CITY OF ELLENSBURG

Memorandum

Date: August 17, 2017
To: Dusty Pilkington, Kittitas County Community Development
From: Craig Jones, Development Coordinator *CJ*
Through: Derek Mayo, City Engineer *DKM*
Re: Commons at Dry Creek formerly Currier Heights

The following are the Public Works comments for the proposed Commons at Dry Creek PUD (PD-16-00001 & LP-17-00004) along Dry Creek Rd. in the UGA.

MDJ CONTRACTORS
CURRIER HEIGHTS PUD
PRELIMINARY SITE PLAN

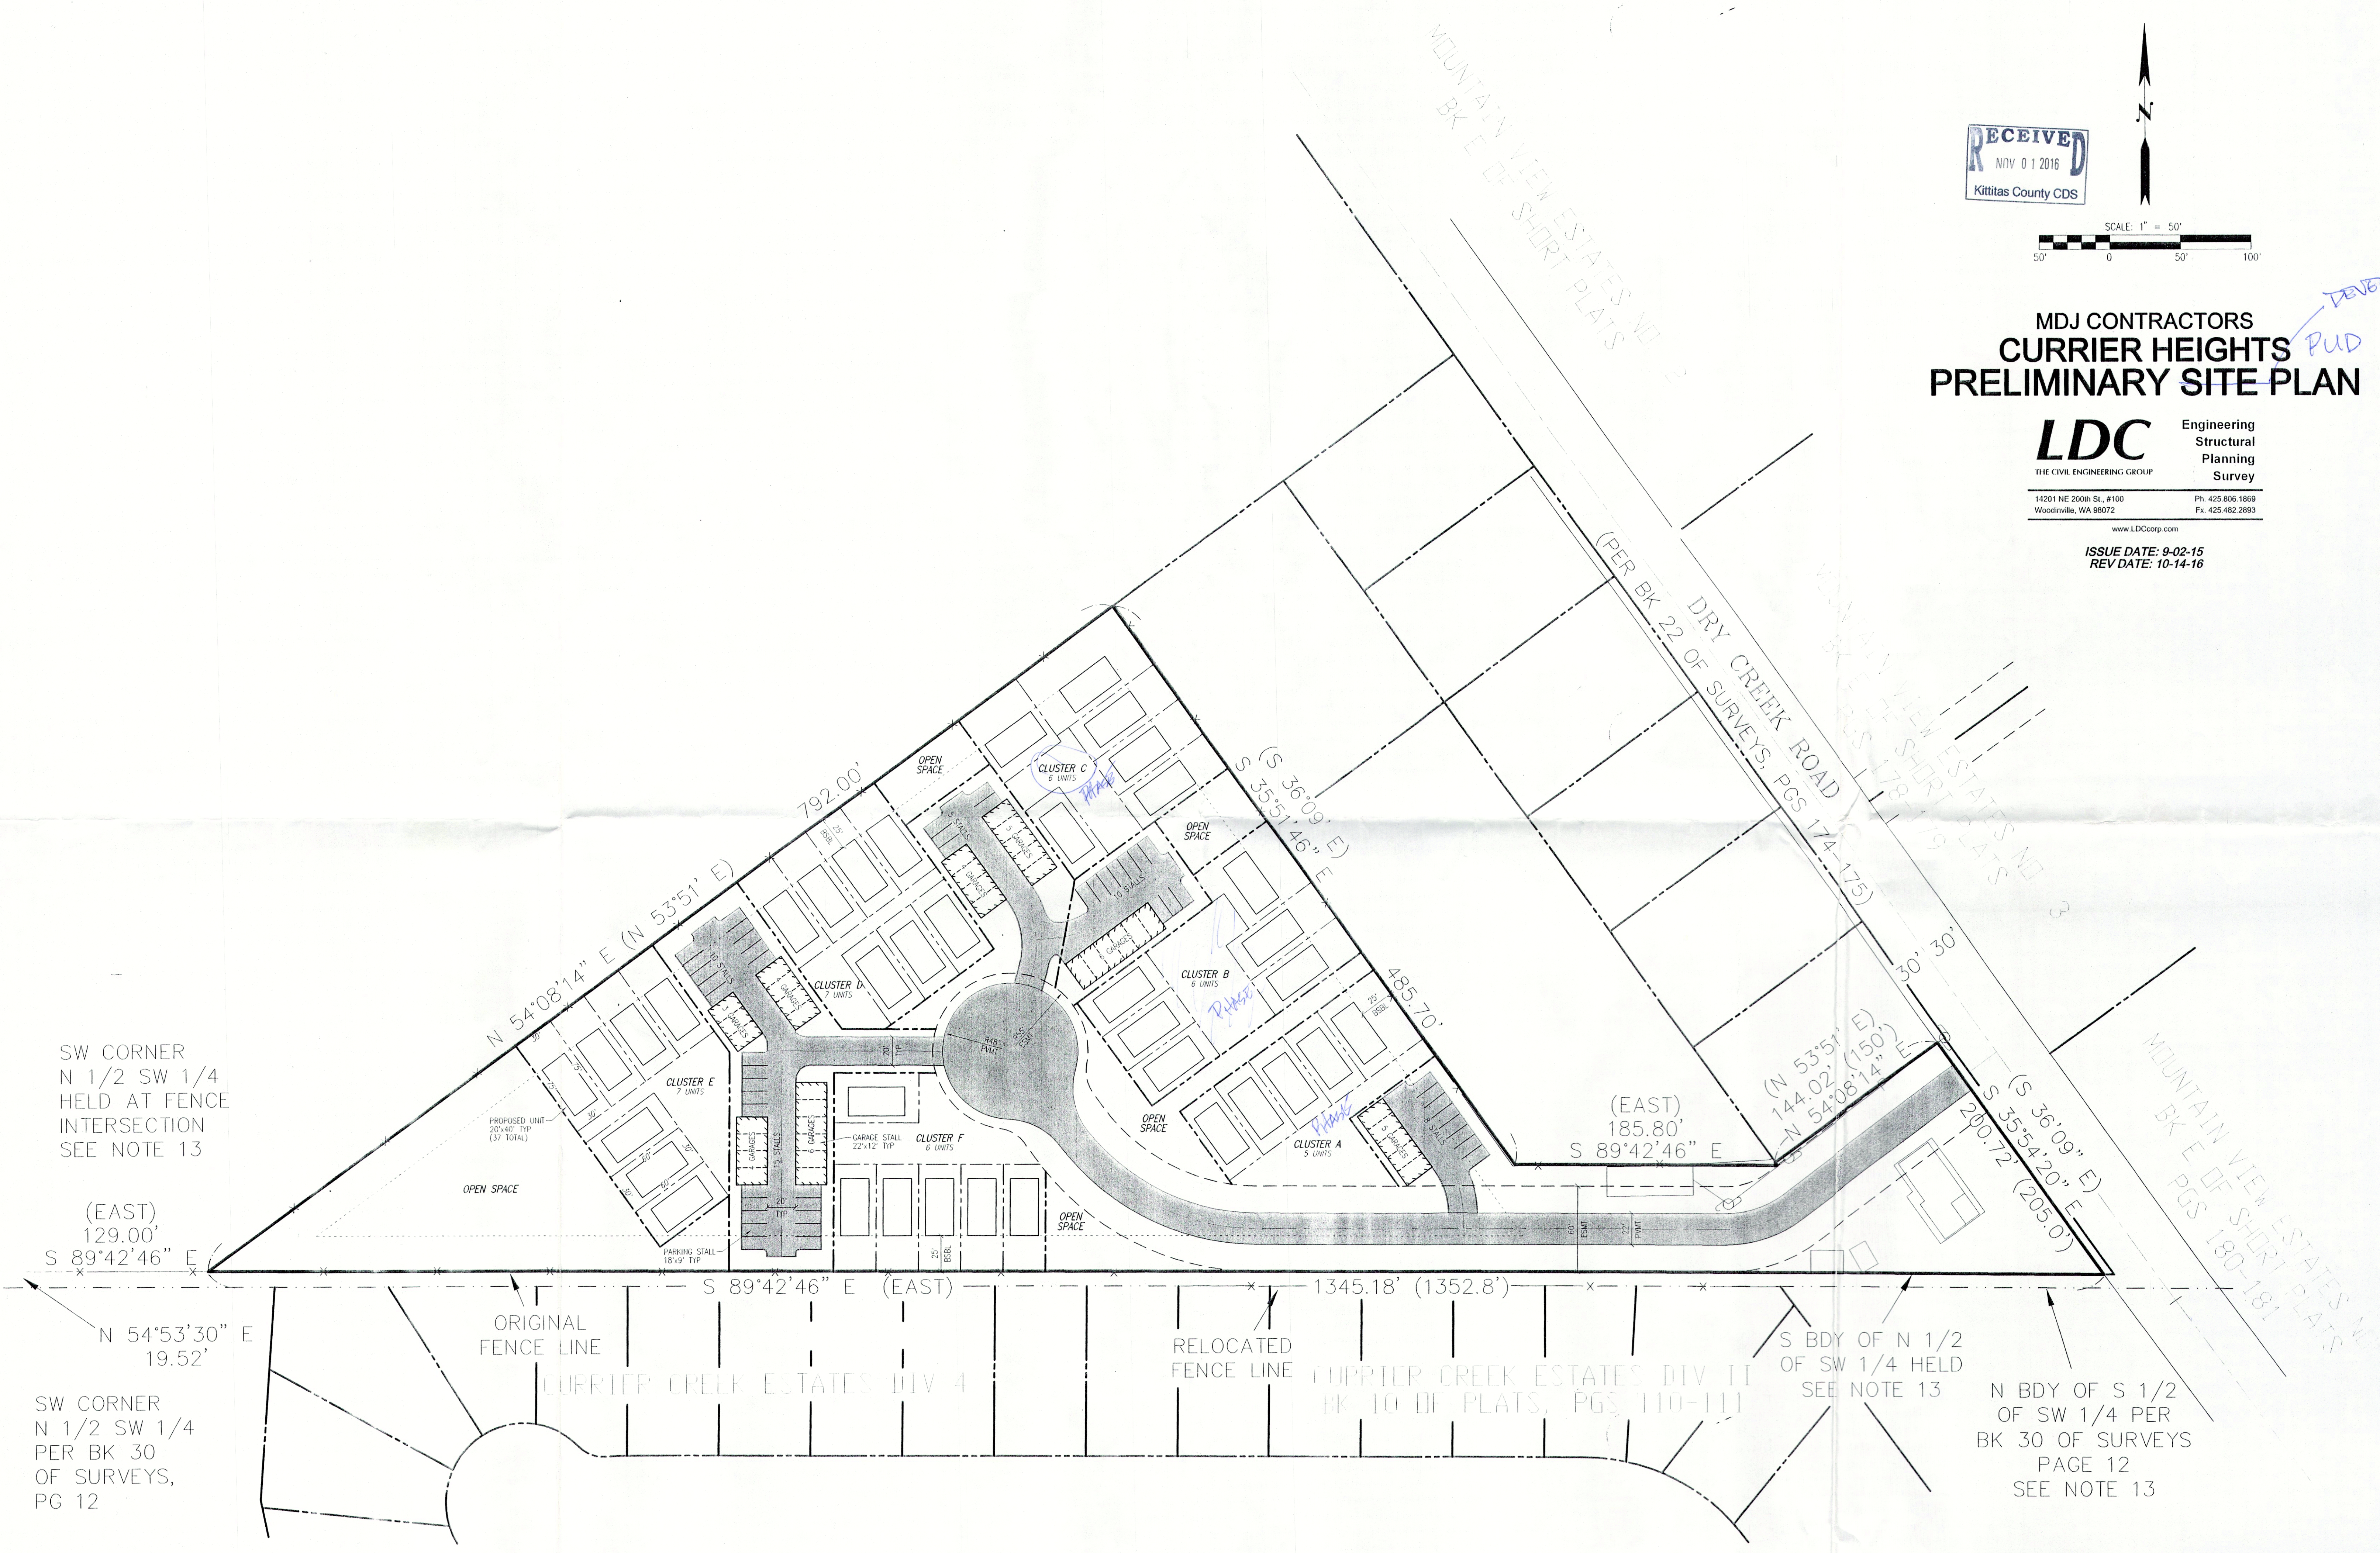
One of the water mains available to serve this development is the 24" Concrete main that runs in Dry Creek Rd. An 8" Ductile Iron main is also stubbed toward this parcel from the south development. To gain access to this stub an easement from the abutting property owner would be required. An 8" main will need to be extended through the project and may be required to be looped for adequate fire flows. Applicants engineer would need to verify. If looping is not necessary than connection to the 8" stub will be required and extending the 8" interior main towards the 24" main without connecting. Each lot will need a separate water service. See attached utility map.

The potential sewer main available to serve this development is an 8" PVC stub from the development to the south. To gain access to this stub an easement from the abutting property owner would be required. An 8" PVC main will need to be extend through the project, as each lot will need a separate sewer service. See attached utility map.

The property is outside the City limits but inside the UGA. This project would trigger the requirement of half street improvements along Dry Creek Rd. The frontage improvements may be deferred by the Utility Extension Agreement and Agreement Waiving Right to Protest LID and Annexation. The internal roads will need to be to City standards and the right of way dedicated. Any structures in the proposed right of way will need to be removed. Street improvements include concrete curb/gutter, sidewalks, street lighting, permanent signage, asphalt, asphalt markings, gravel base, storm drainage, and other items associated with minimum public improvements consistent with Public Works Development Standards.

The current storm design requirements are based on treating the first ½” of rainfall on the property, and storm drainage detention on a 10 year storm event (1.2” of precipitation/24 hours) and retention facilities based on a 25 year storm event (1.6” of precipitation/24 hours). Depending upon the storm water control plan proposed by the developer, the City of Ellensburg may require additional right of way or easements for on site storm water treatment, prior to discharge off site. The preliminary plat indicates detention areas for storm water detention and flow control. Specific issues related to storm water will be reviewed at time of civil plan submittal.

The applicant’s design engineer should determine groundwater elevations in the vicinity of proposed storm water treatment and flow control facilities. The water surface elevation needs to be utilized in the facility designs and should be verified when groundwater is at its highest. Typically the groundwater in the Ellensburg area is elevated from April 15th through October 15th. However, groundwater on the subject site may not be associated with seasonal irrigation and could crest at another time during the year.
